Re: Boundary & Topo Lots 10 & 11 B1k 3
Royal Heights Addition

Submitted herewith are two copies of Grading and Drainage Plans for proposed development at 1220 Juan Tabo N.E.

GRADING & DRAINAGE PLAN

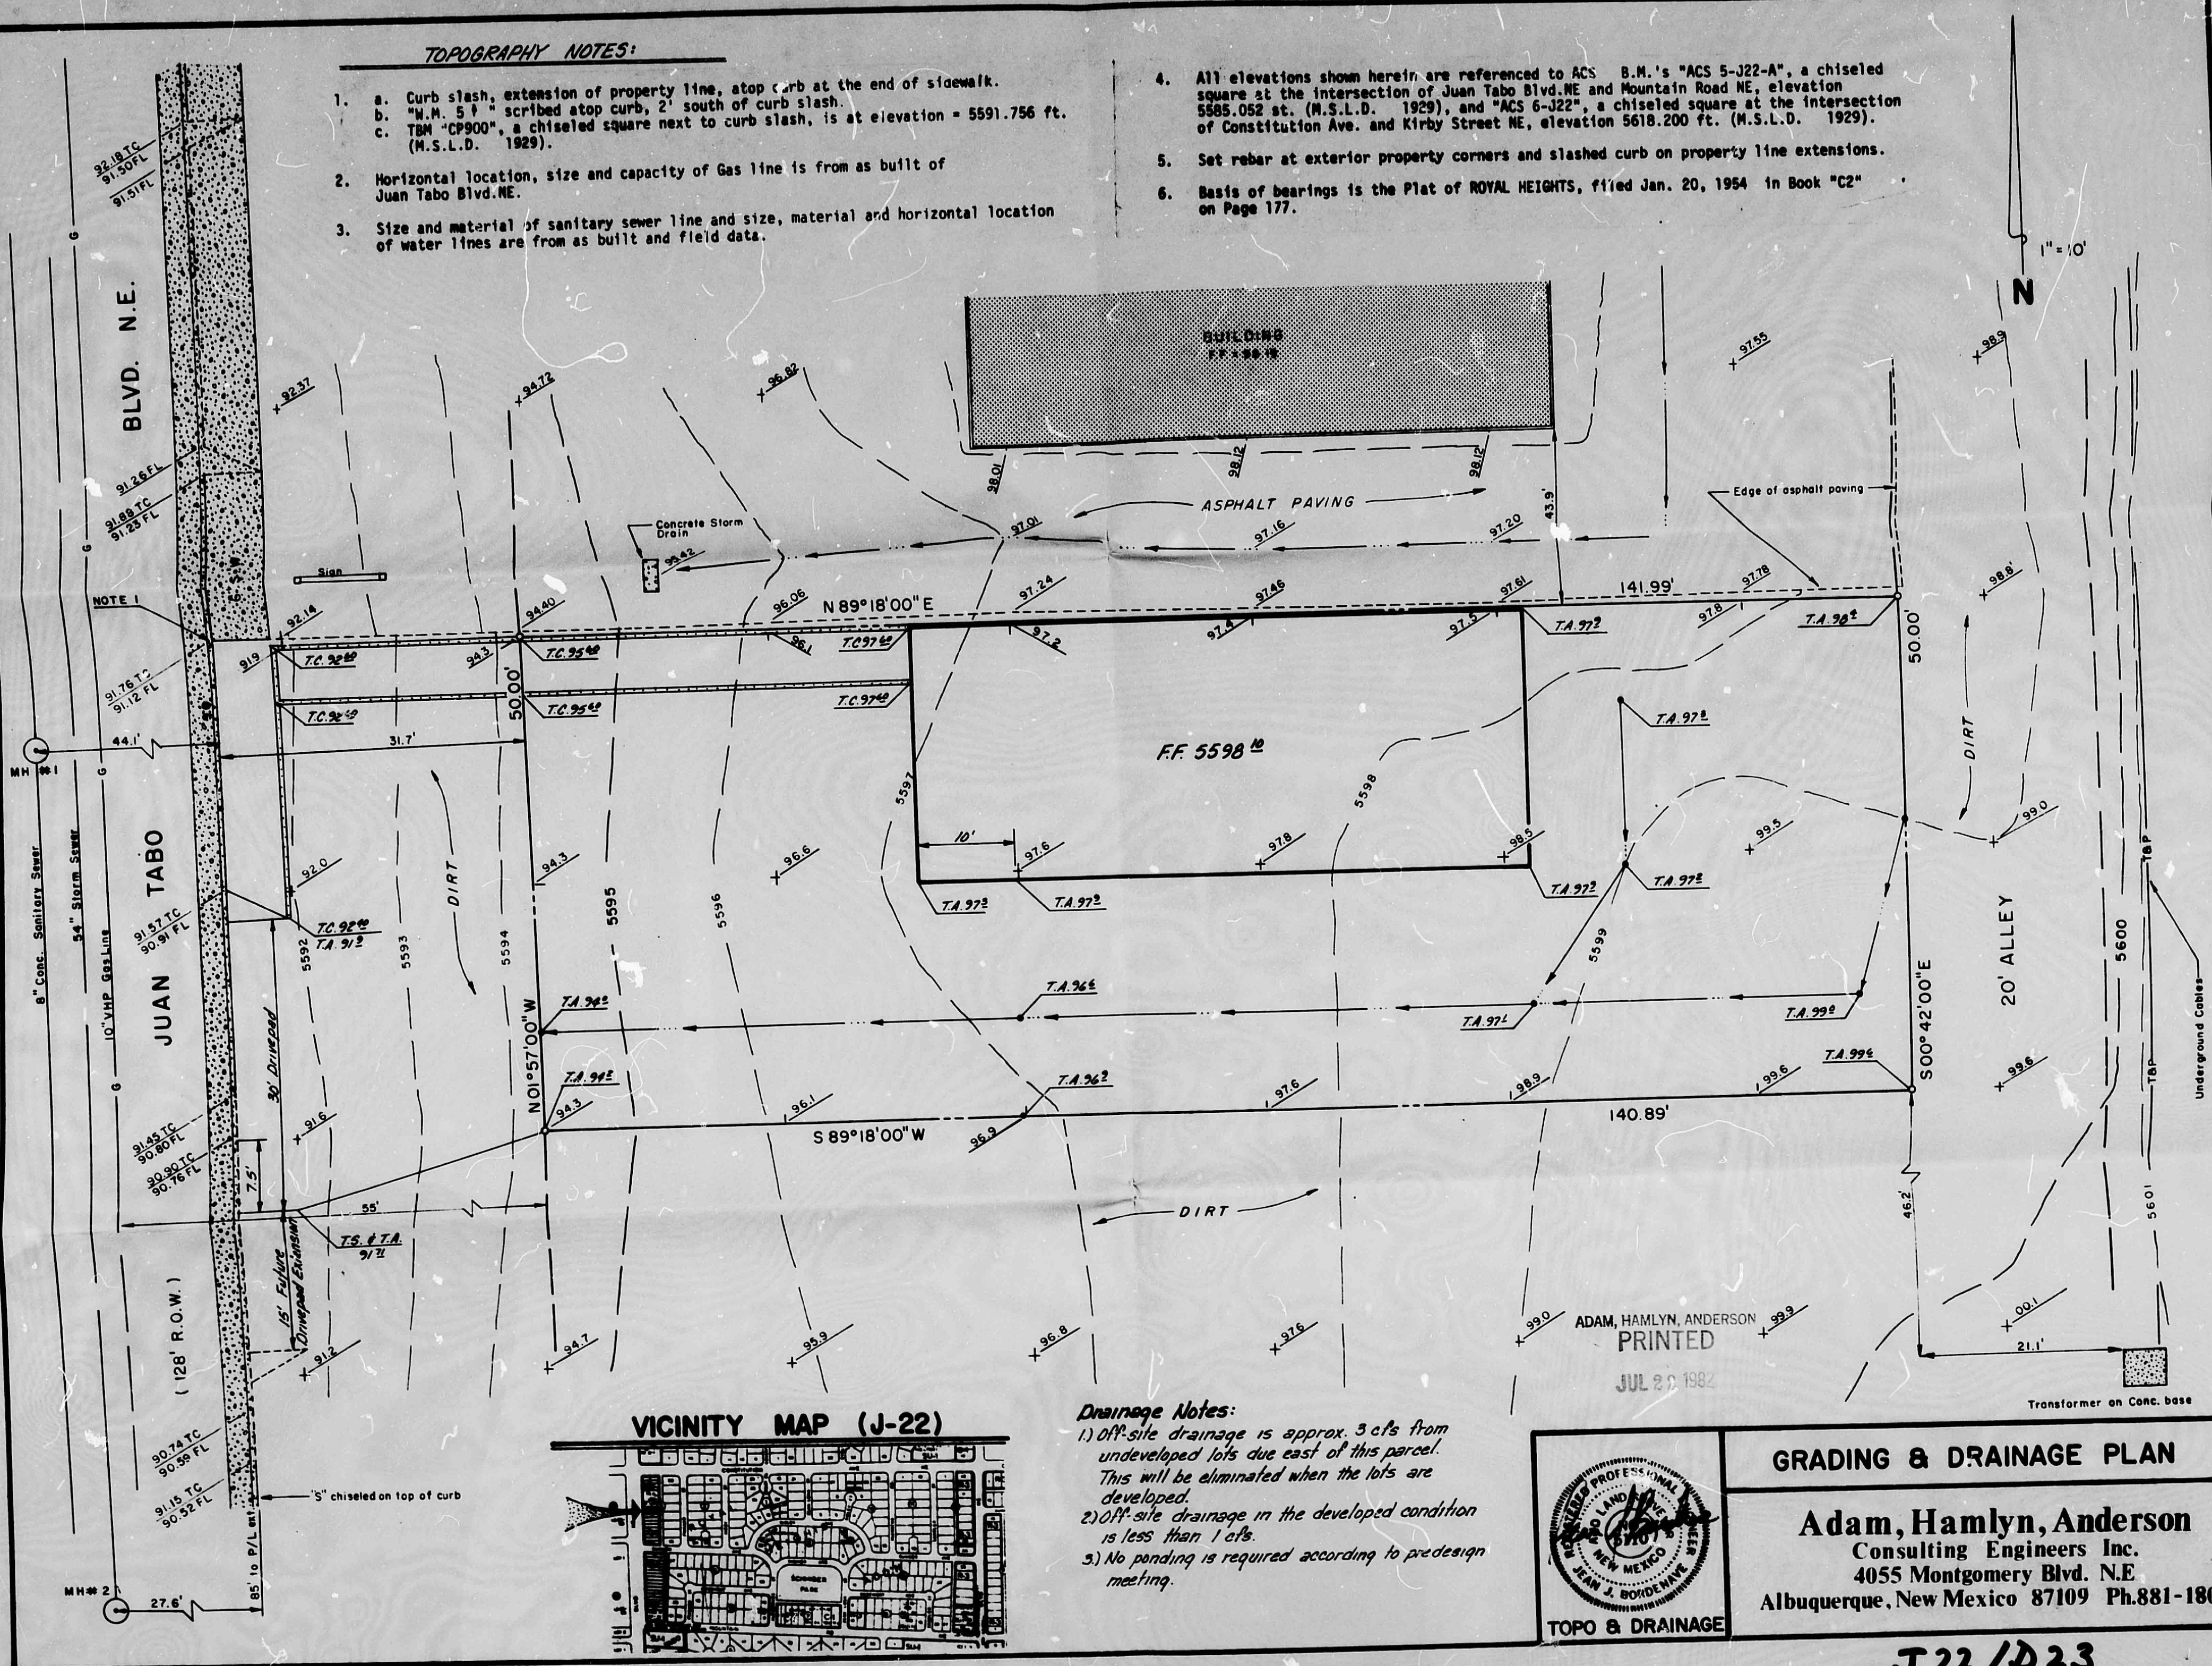
grading-drainage plan
 needed contact our office
 2/4 or have any questions

APPROVED FOR DRAINAGE
 8-17-82
